EL PASO COUNTY DEVELOPMENT SERVICES DEPARTMENT

Revised May 27, 2022

Colorado Springs, CO 80910 Re: HIGH PINES PATIO HOMES PHASE 2E – Letter of Intent

**SITE DEVELOPMENT PLAN AND AS-BUILT EXHIBIT**  
"HIGH PINES PATIO HOMES PHASE 2E" - A PORTION OF THE NE4 OF SECTION 2, TOWNSHIP 11 SOUTH, RANGE 67 WEST OF THE 6TH P.M., EL PASO COUNTY, COLORADO

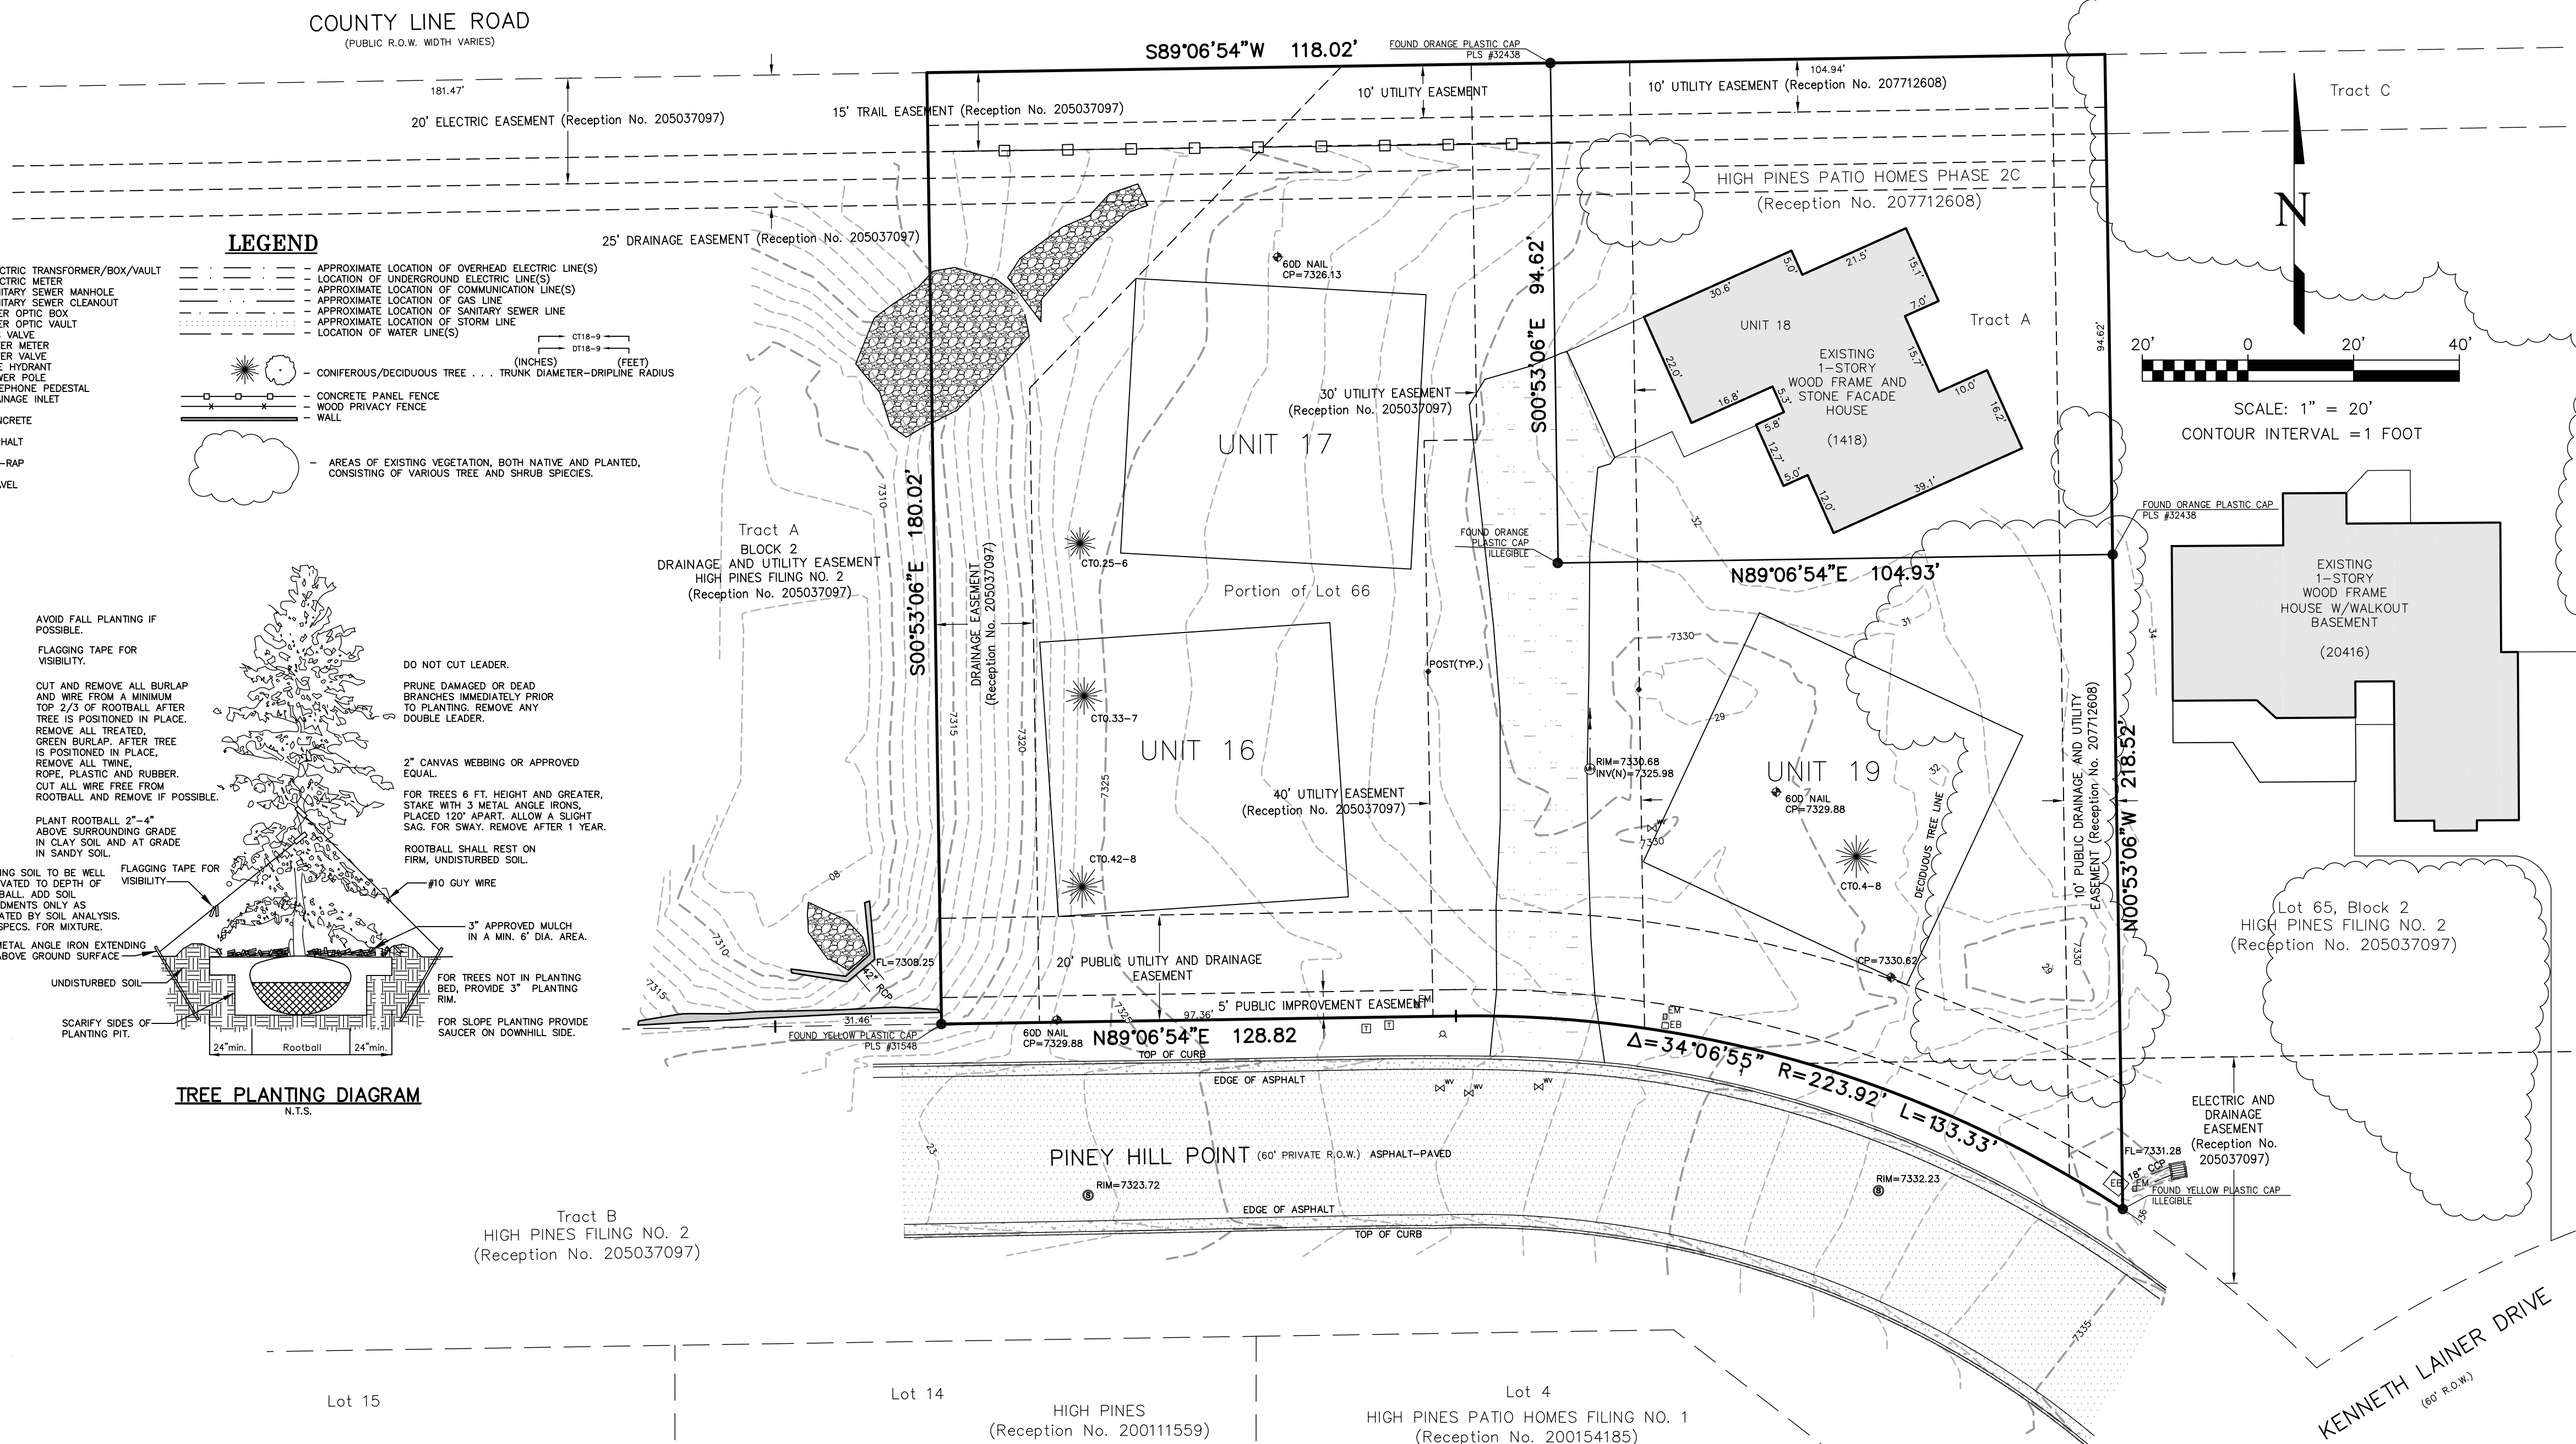
Please discuss water quality and detention for this site. Does the site already have water quality? or will it have to be built with this development? If there is a pond please confirm it has capacity for the development.
